**Date:** September 18, 2020

**Re:** 5202 Forest Ave SE Permit # 2007-212  
5202 Forest Ave SE  
Mercer Island, WA 98040

**Subj.:** First Intake Screening Comments Response

1 LOT 4 TREE PLAN
SCALE: 1/8" = 1'-0"

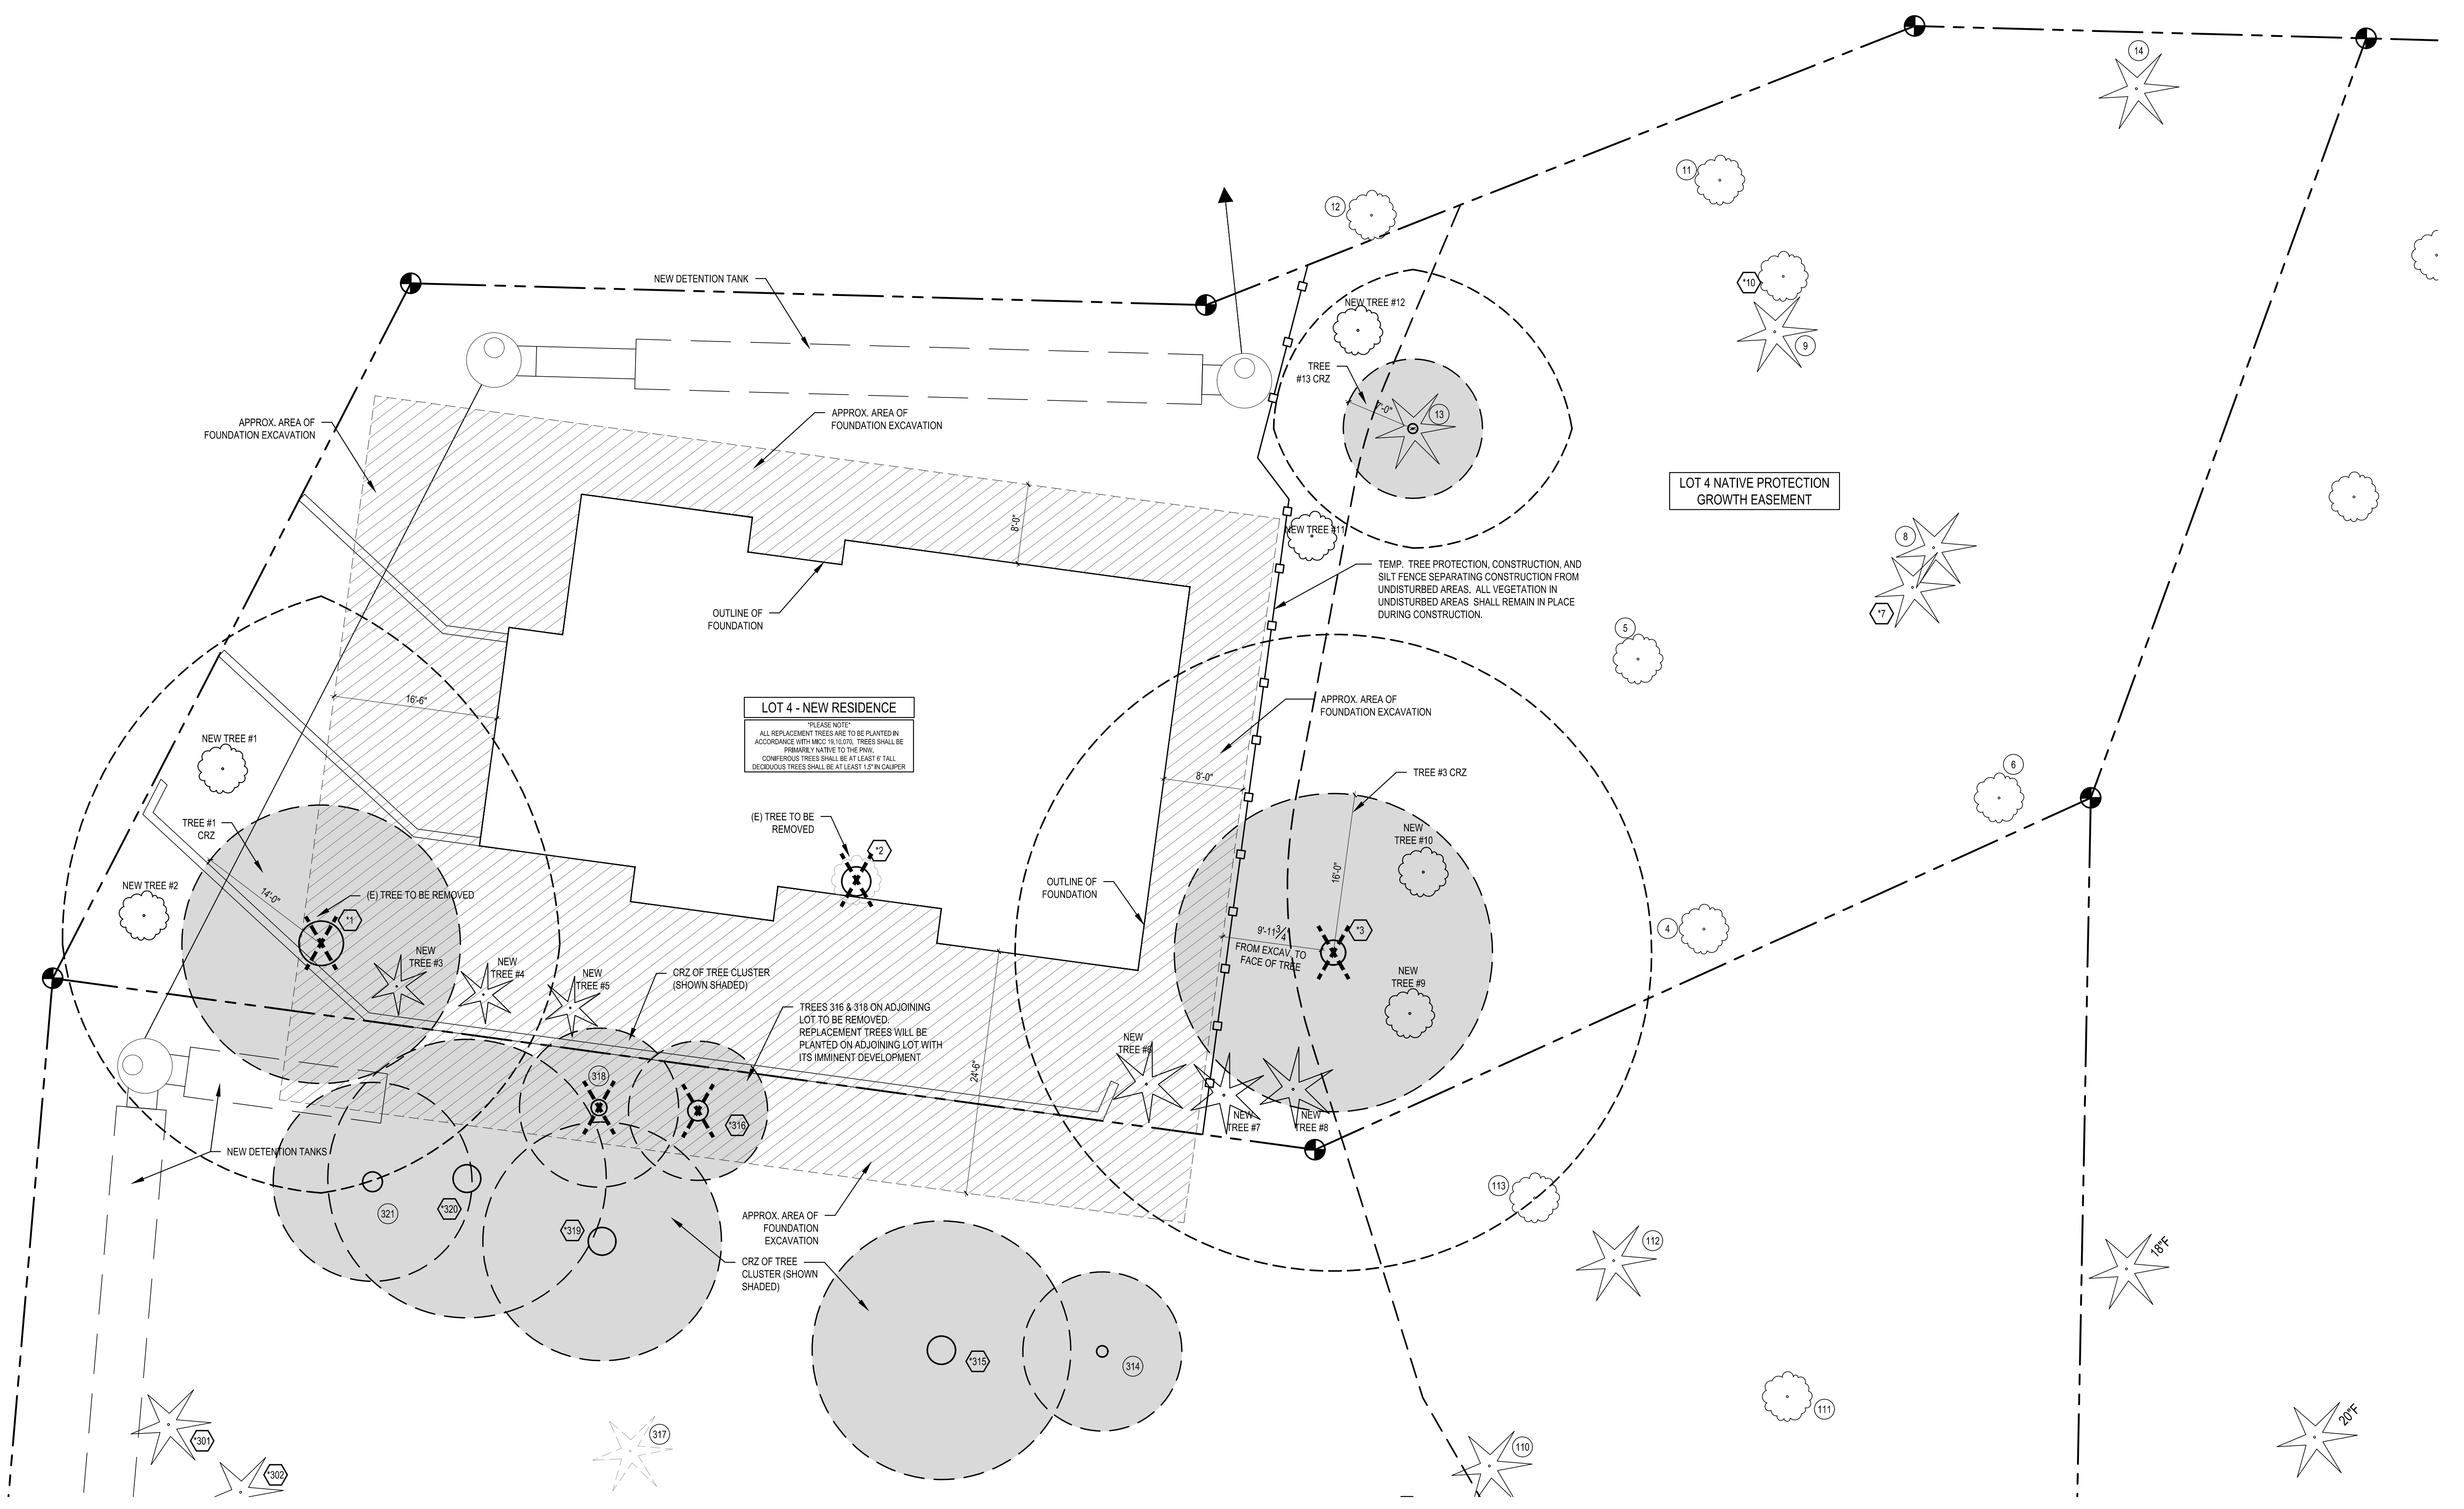
4. *Tree Comments – John Kenney  
“Trees 1 and 2 are exceptional and listed as viable in the Arborist’s report. Exceptional trees can only be removed if justified under MICC 19.10.060.A.3”*

5. *See below for first round comments in above checklist. Checklist items not required for intake”  
“First round comment  
2. Minimize grading encroaching into three 3’s dripline. Or use other methods like shoring.”*

**Response: Please see revised uploaded arborist’s report and uploaded ISA Basic Tree Risk forms for both trees 1 and 2 created by Tom Hanson, arborist.**

**Response: Please see revised arborist’s report uploaded to the city ftp site, notably page 5. Tree #3 was hoped to be retained, but is a very old tree overhanging the house with potential for significant root excavation decay and in the arborist’s judgement should be removed as well.**

DATE: 9/15/20
 SCALE: AS SHOWN
 DRAWING NO: **C1.0**
 1 OF 5

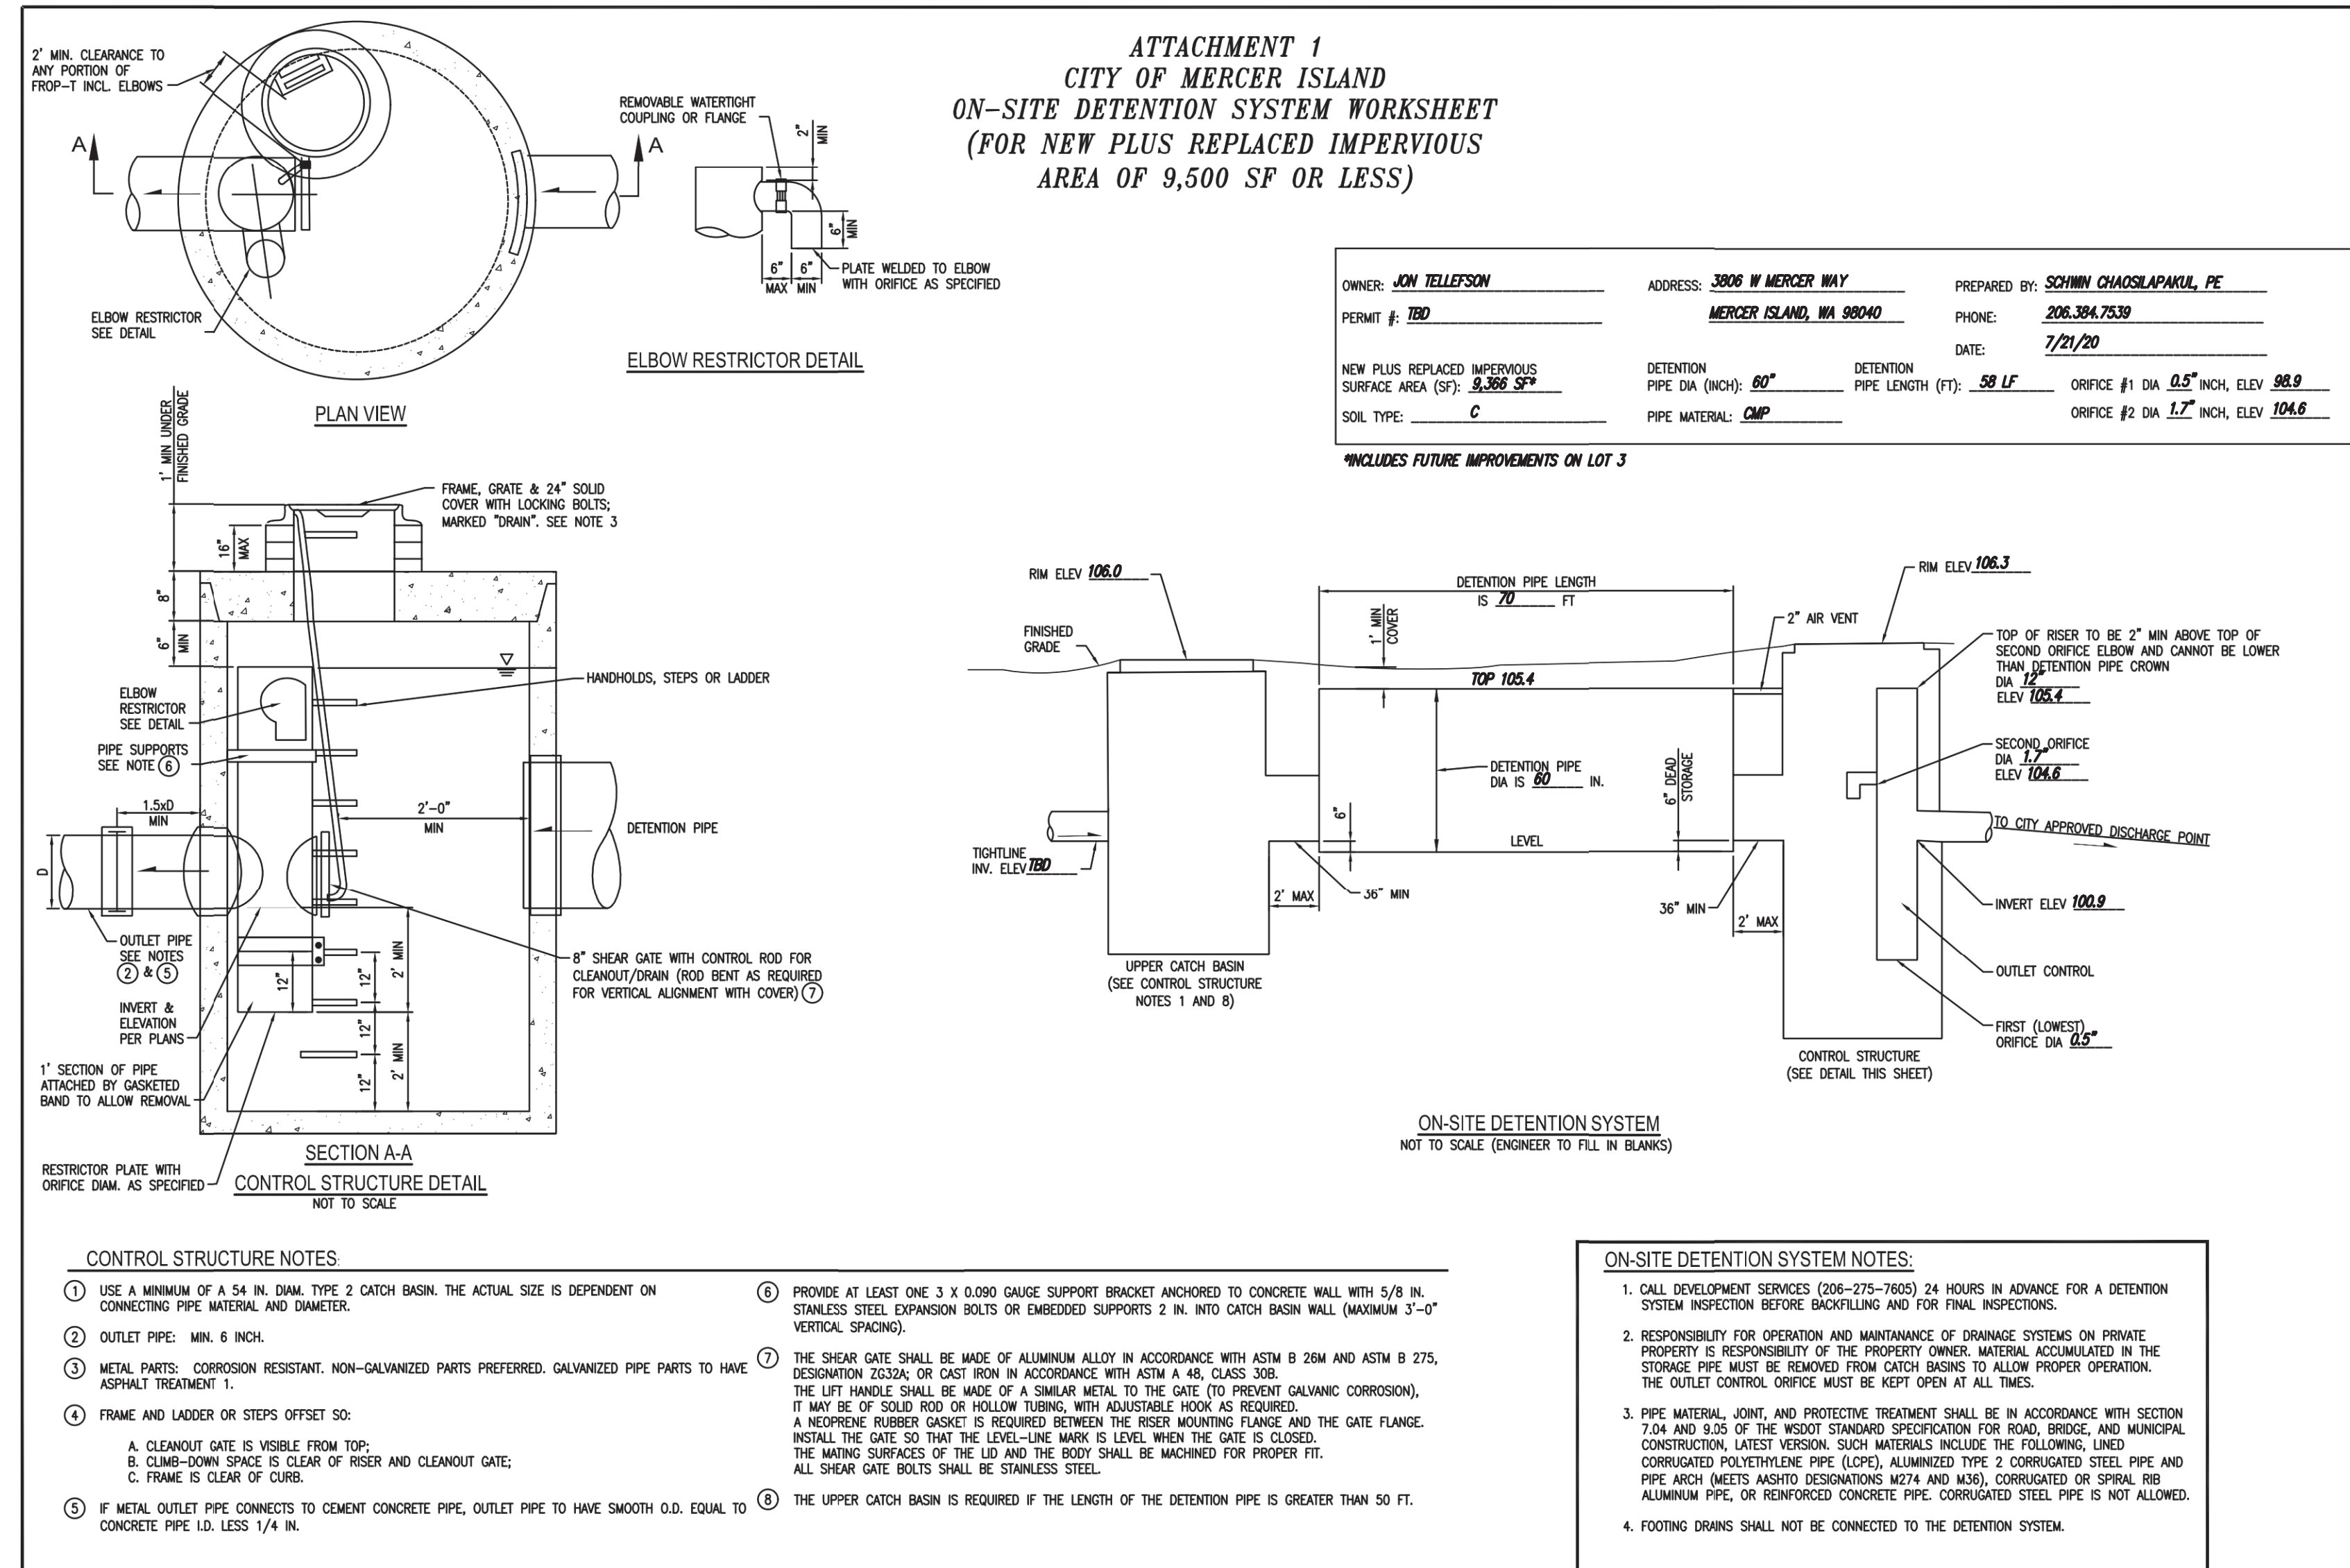
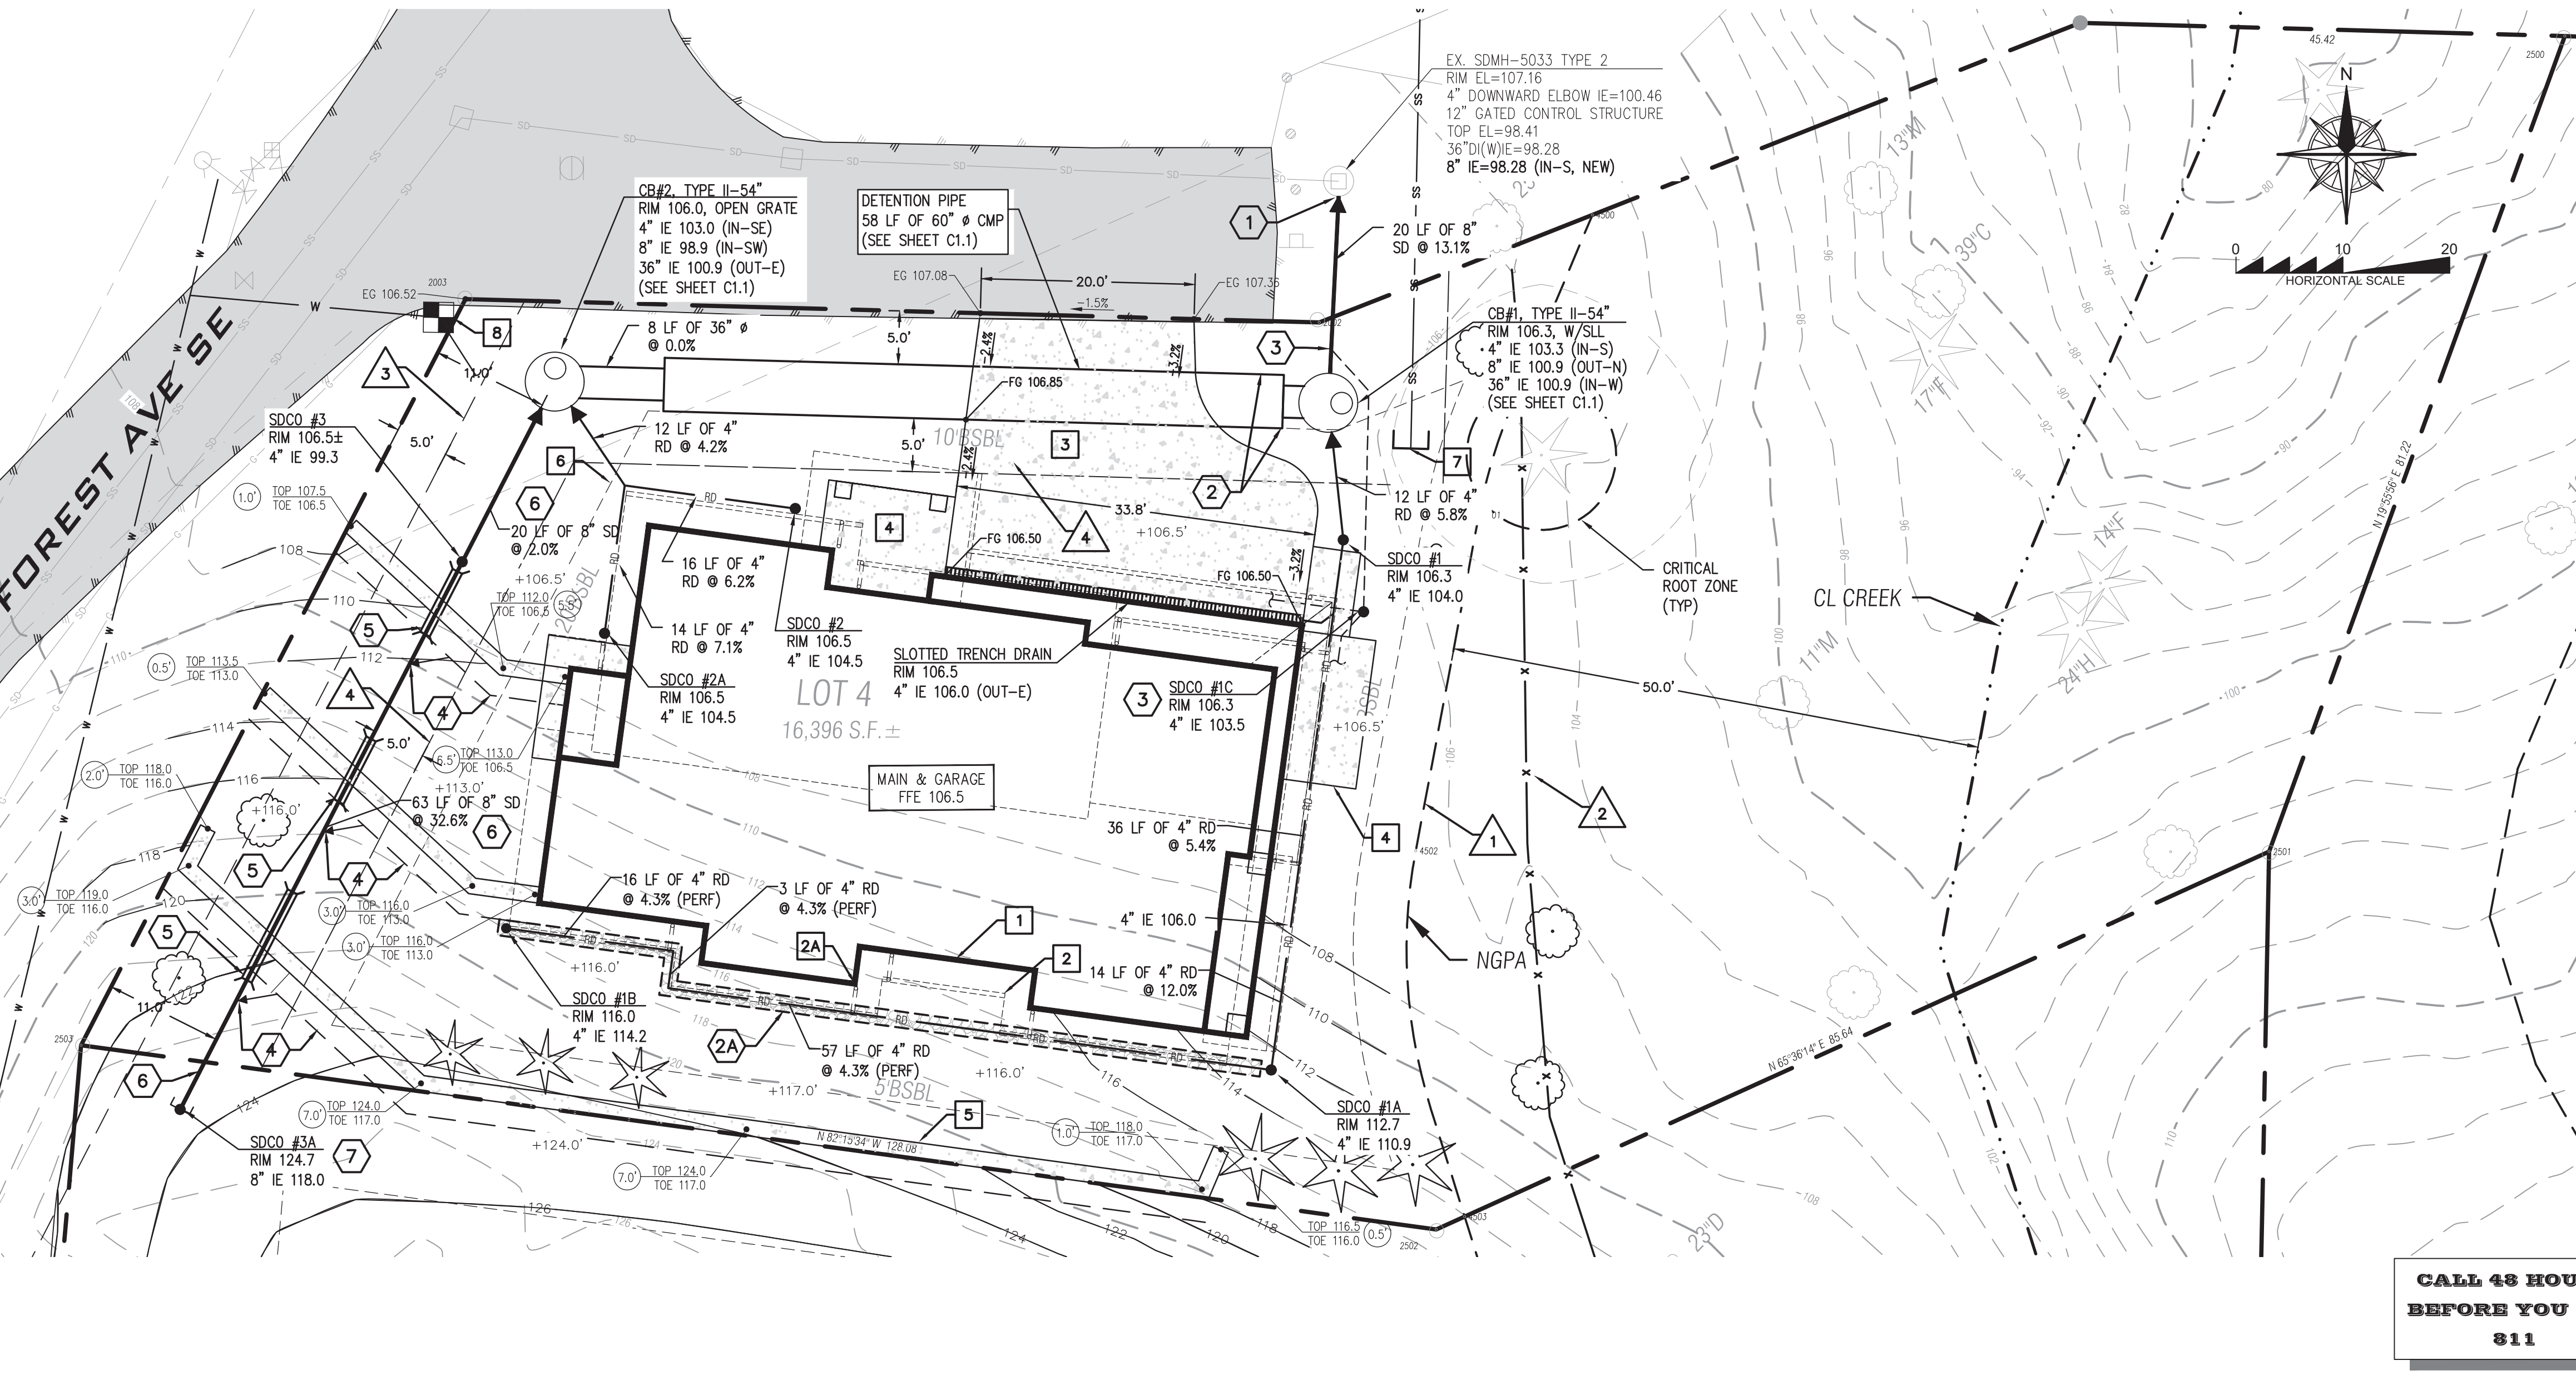
2. *“Additional comments:  
This permit is only for one lot, all design features other than this lot shall be deleted or removed, such as The Detention System Exhibit”*

**Response: The Detention System Exhibit has been removed from the set in addition to the updated civil drawings mentioned in the previous comment.**
